SCOPING OPINION:

Wheelabrator Harewood Waste to Energy Facility

Case Reference: EN010104

April 2019

Figure 1-1: Site Location Plan

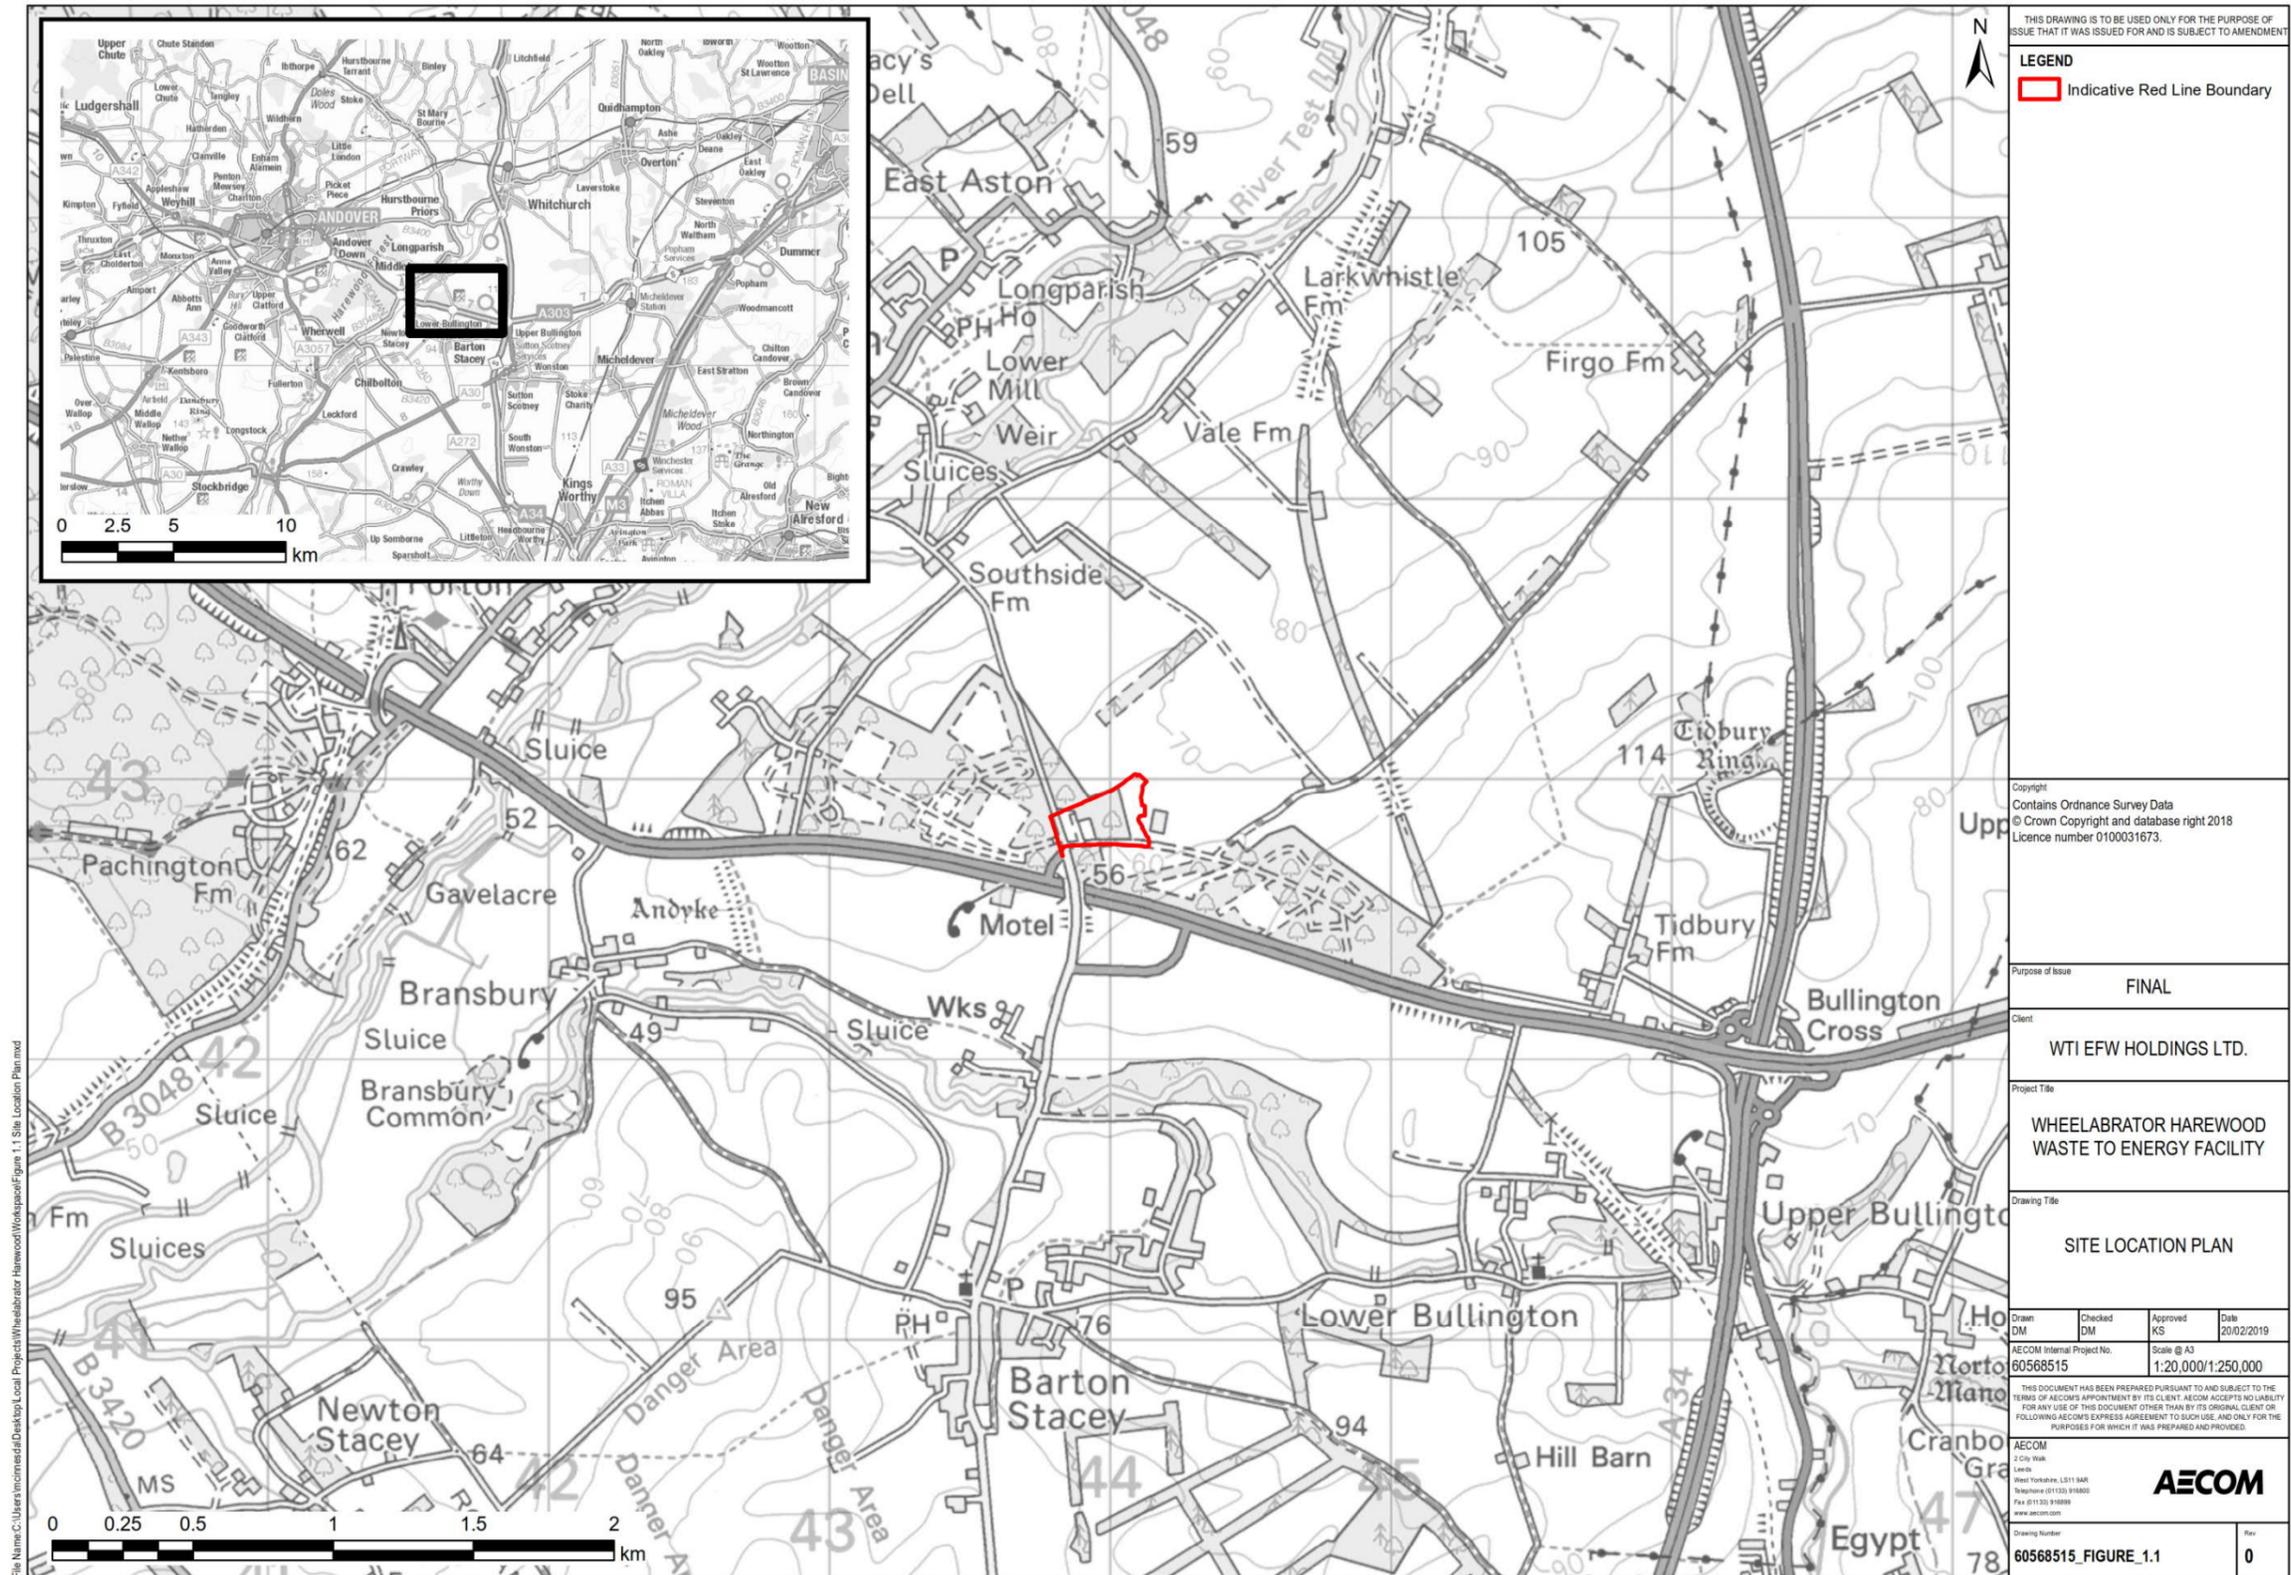
2.2.3 The Proposed Development is to be located at the A303 Enviropark at Drayton Road as shown in Figure 2.1 of the Scoping Report, approximately 1.8km north of Barton Stacey and 7km east of Andover. The site extends to 5.7 hectares on undeveloped grassland and is adjacent to the operational boundary of an existing waste and aggregate recycling facility, comprising a Materials Recycling Facility (MRF) and Incinerator Bottom Ash (IBA) Recycling

Figure 3-1: Permanent and Temporary Land Take

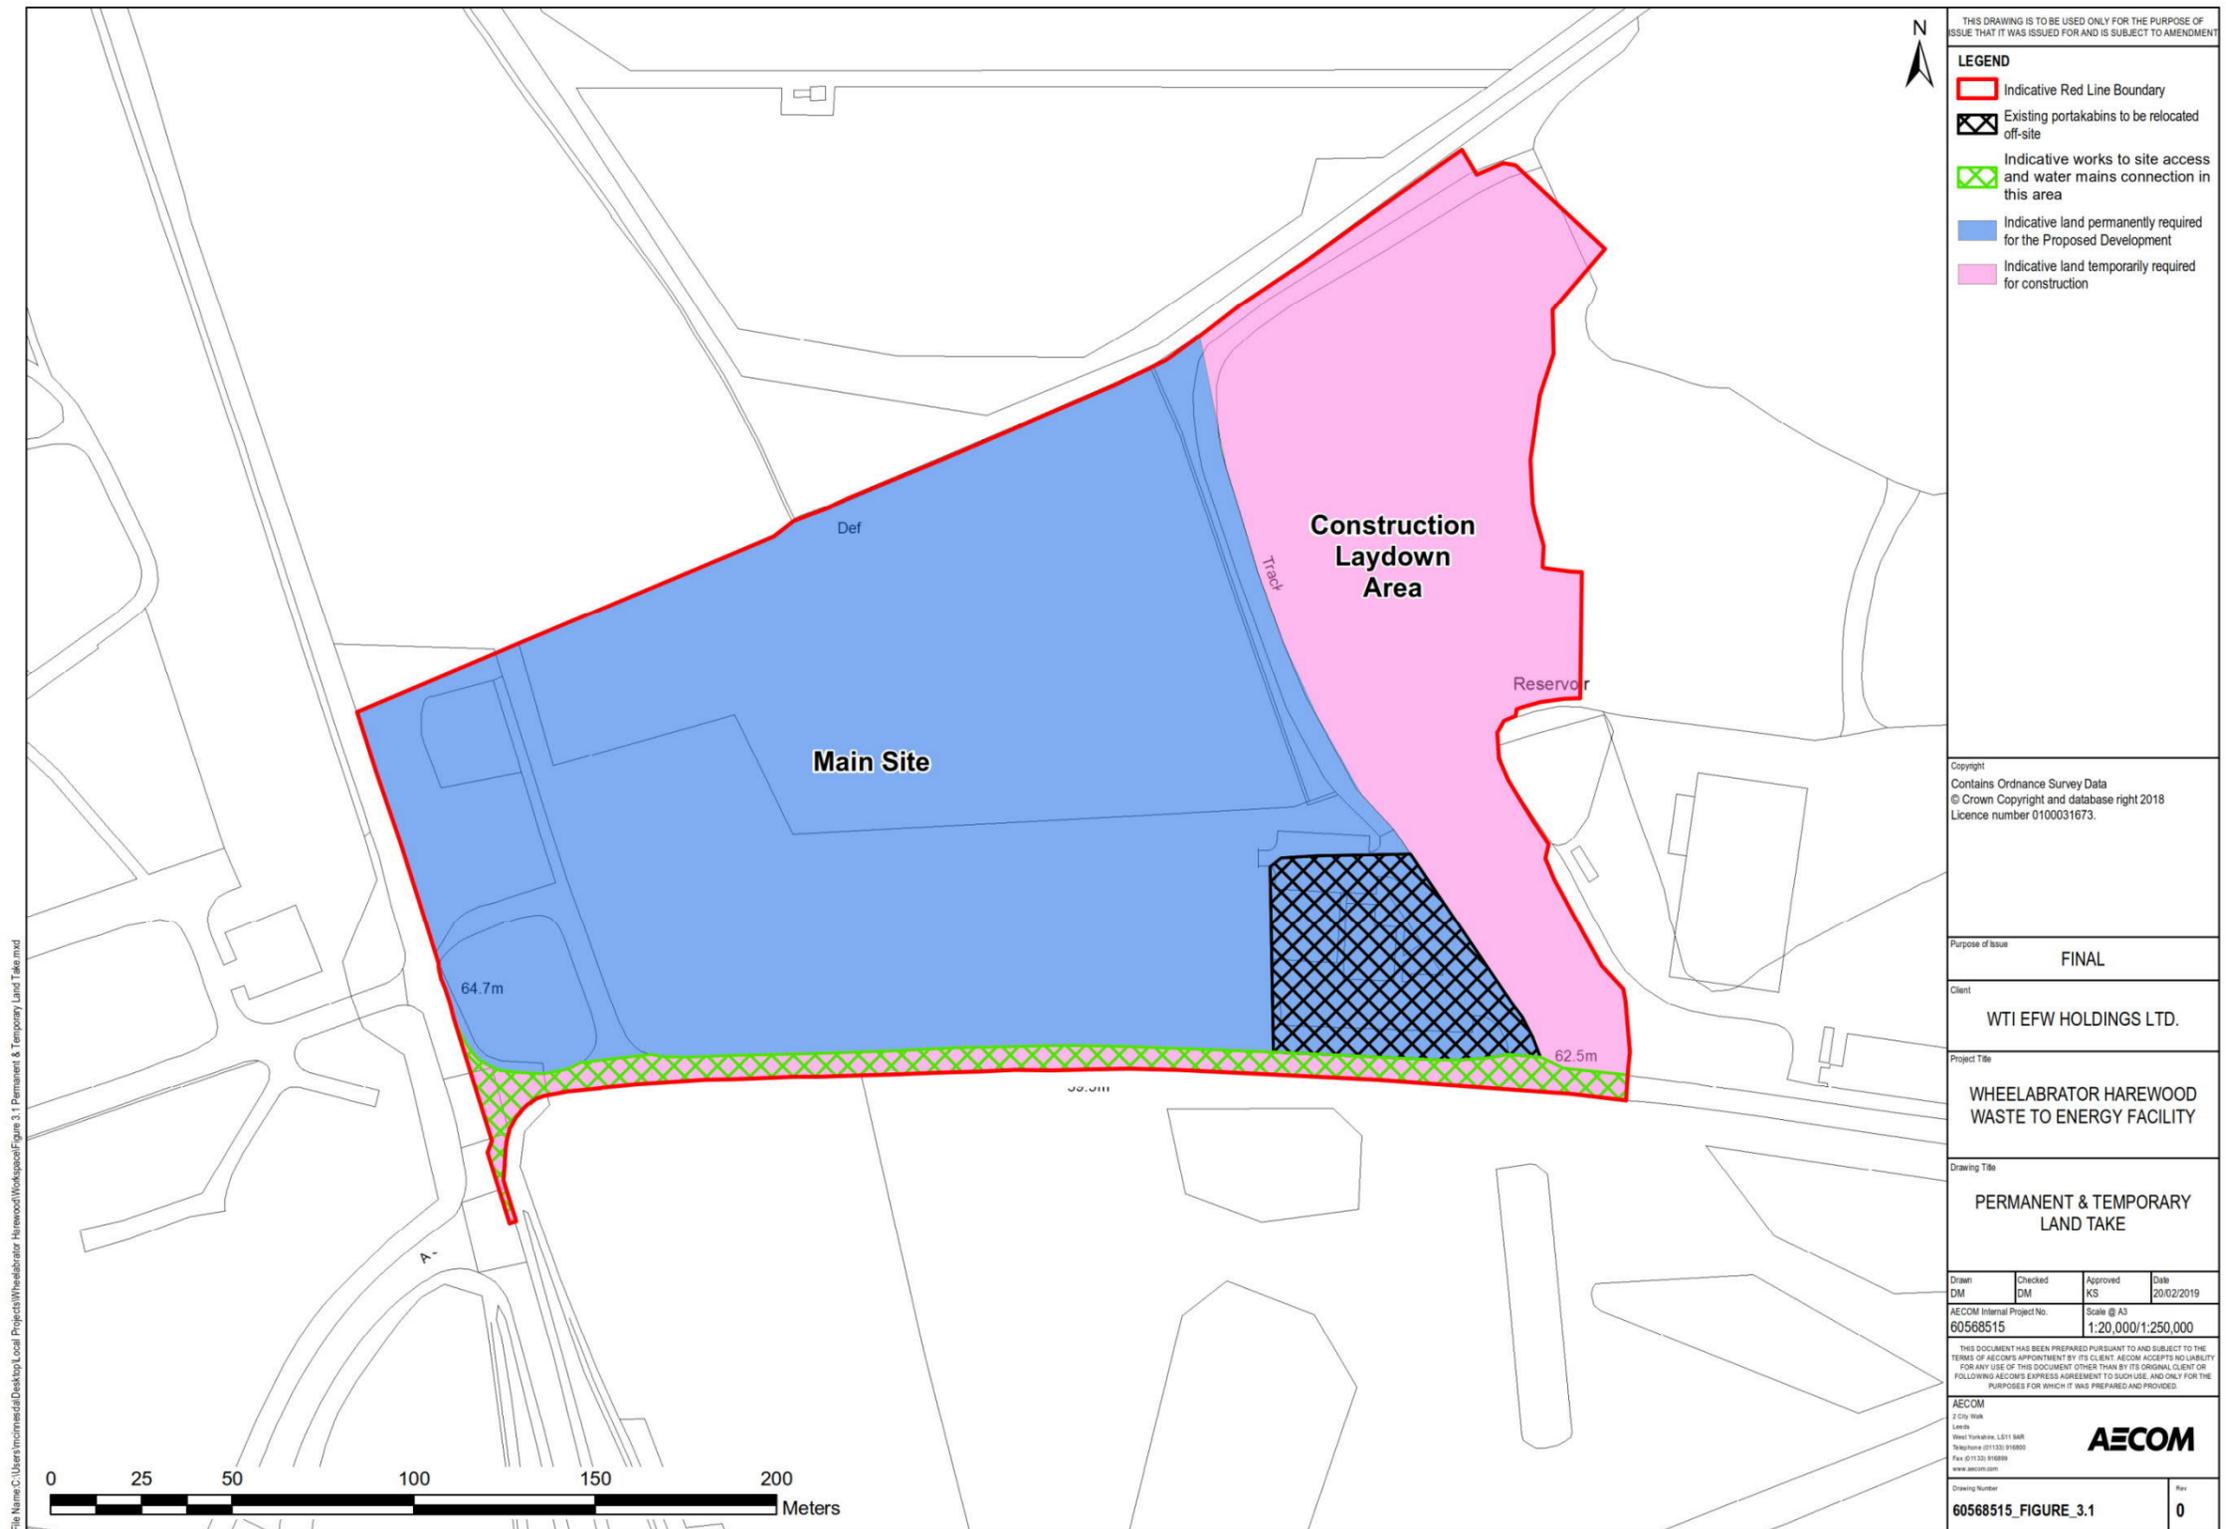
- 2.3.6 Construction of the Proposed Development is anticipated to last approximately 3 years and is expected to commence from March 2020. The ES should contain a general construction programme so that it is clear how and when the specific works will take place and how any resulting effects on the road network are to be managed. It should provide a description of the land use requirements during both the construction and operational phases. It is also important that the ES clearly identifies and distinguishes between areas of land or works which are required either permanently or on a temporary basis.
